Chau Chak Wing Museum

Response to Heritage Council Submission

State Significant Application SSD 16_7894

6 September 2017

Drawing Title
SITE PLAN

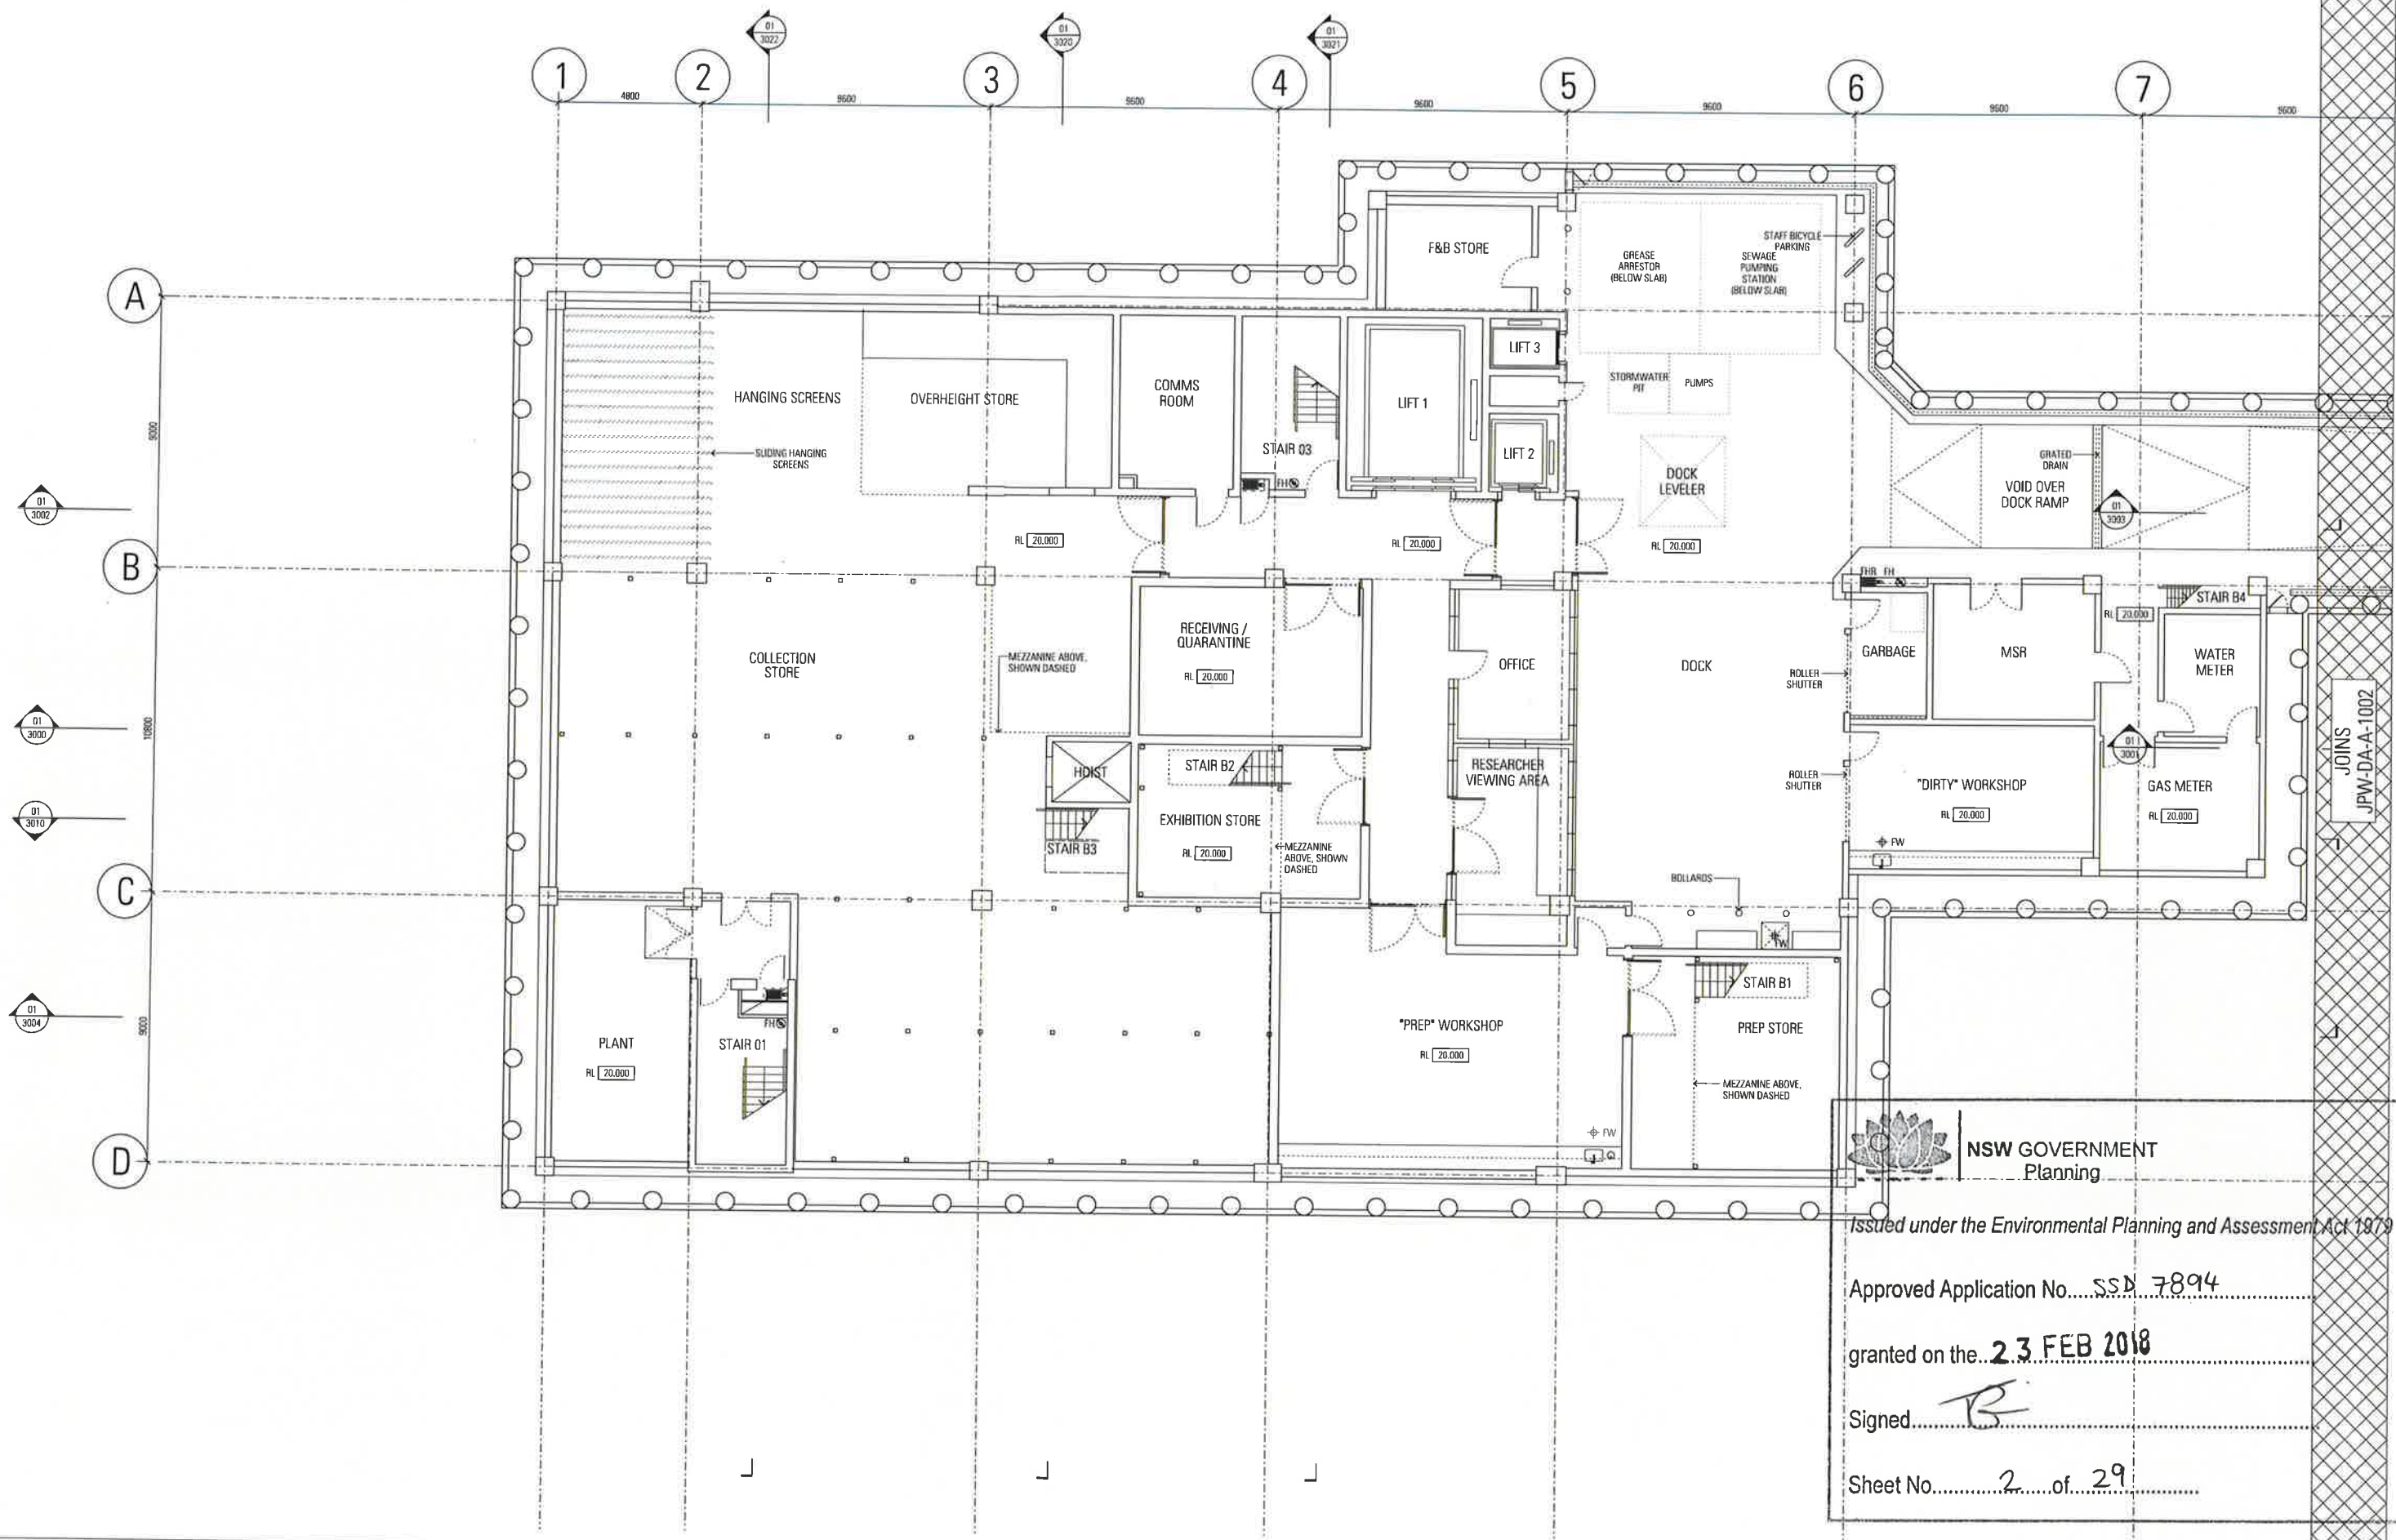
Heritage Council Comment	Proponent Response
The view towards the loading dock entry from Baxter's Lodge (View E) photomontage confirms Heritage Council concerns that the impact of the loading dock, located at the main entry to the University is unacceptable.	<p>The "View E" referred to by the Heritage Council was prepared by Richard Lamb & Associates in conjunction with JPW Architects, and was included in the "Certification of View Analysis Assessment Report" within the SSDA, that was intended to "provide certification of the adequacy and accuracy of block photomontages only" ("Certification of View Analysis Assessment Report" by Richard Lamb & Associates, dated 17 May 2017, page 1).</p> <p>This view was not intended to convey a photorealistic "CGI" representation of this aspect of the building design.</p> <p>USYD has however further developed the design of the loading dock entry, and hereby responds with amended drawings, and three "before and after" photos from differing approach perspectives.</p> <p>USYD believes that the proposed location of the loading dock entry driveway is the most appropriate design outcome, and this is demonstrated in the three photomontages included in this response.</p> <p>Upon arriving to site through the Parramatta Road entry gates, the driveway is hidden behind the shadows of the existing trees, as well as being tucked in behind the existing sandstone gate pillar on the western side of the University entrance. This is validated by Image 1, representing the experience of arriving by vehicle or on foot from Parramatta Road travelling in a westerly direction.</p>

It is not designed as a counterpoint for the gate house (Baxter's Lodge).	<p>The argument for the loading dock entry being a counterpoint to Baxter's Lodge is neither logical nor appropriate, since the definition of a counterpoint element can be "a contrasting and parallel element, item or theme"; or "any element that is juxtaposed and contrasted with another".</p> <p>The proposed design however satisfies both definitions, in that the existing sandstone gate pillar on the western side of the University entrance, into which the proposed loading dock entry interlocks, is an appropriate "parallel element"; whilst the "negative space" of the loading dock entry, clad in high quality stone materials, is an appropriate contrasting element to the "positive space" of the Baxter's Lodge urban footprint.</p> <p>The design strategy for the dock entrance has been to minimise visual impacts from Parramatta Road and the main pedestrian axis between Victoria Park and The Quadrangle, without compromising the legibility and prominence of Baxter's Lodge and the University Gates at this entry to the Campus.</p>

The design does not sit comfortably within the site.	<p>As demonstrated in Image 1, the loading dock entry is located as close as possible to the University entry gates, which allows the majority of the existing site curtilage on University Avenue to be preserved as open landscape.</p> <p>Image 3 offers further evidence that the placement of the loading dock entry close to Parramatta Road is a minor component of the overall view when experienced by the majority of pedestrians arriving at the University via the steps from Victoria Park, when the mounded grass landscape and curved low sandstone wall curtilage is the dominant visual cue.</p> <p>Furthermore, any alternative entry point to the basement would be detrimental to the Quadrangle forecourt if placed to the west, and impossible due to existing tree roots if placed to the south.</p>
The design of the loading dock is not well resolved and the utilitarian design has an unacceptable impact on the heritage values of the site.	<p>USYD has continued to refine the design of the loading dock entry since the SSDA submission, and photomontage Image 2 illustrates a closer view (from Baxter's Lodge) of the existing sandstone retaining wall, and how this integrates with the new high quality materiality of the various terraced walls, the new steps at the end of the existing northern pathway, and the visual bulk and scale is further reduced by the introduction of planting and hedges.</p> <p>The proposed alignment of the roadway and roller shutter position enable the landscape levels around the dock entry to be neatly tied back into the existing topography, so that the existing slope and character of the landscape is the dominant expression, rather than the physical expression of the dock entry itself.</p> <p>The materiality and detailing of the dock entrance and surrounds is consistent with the main building.</p>
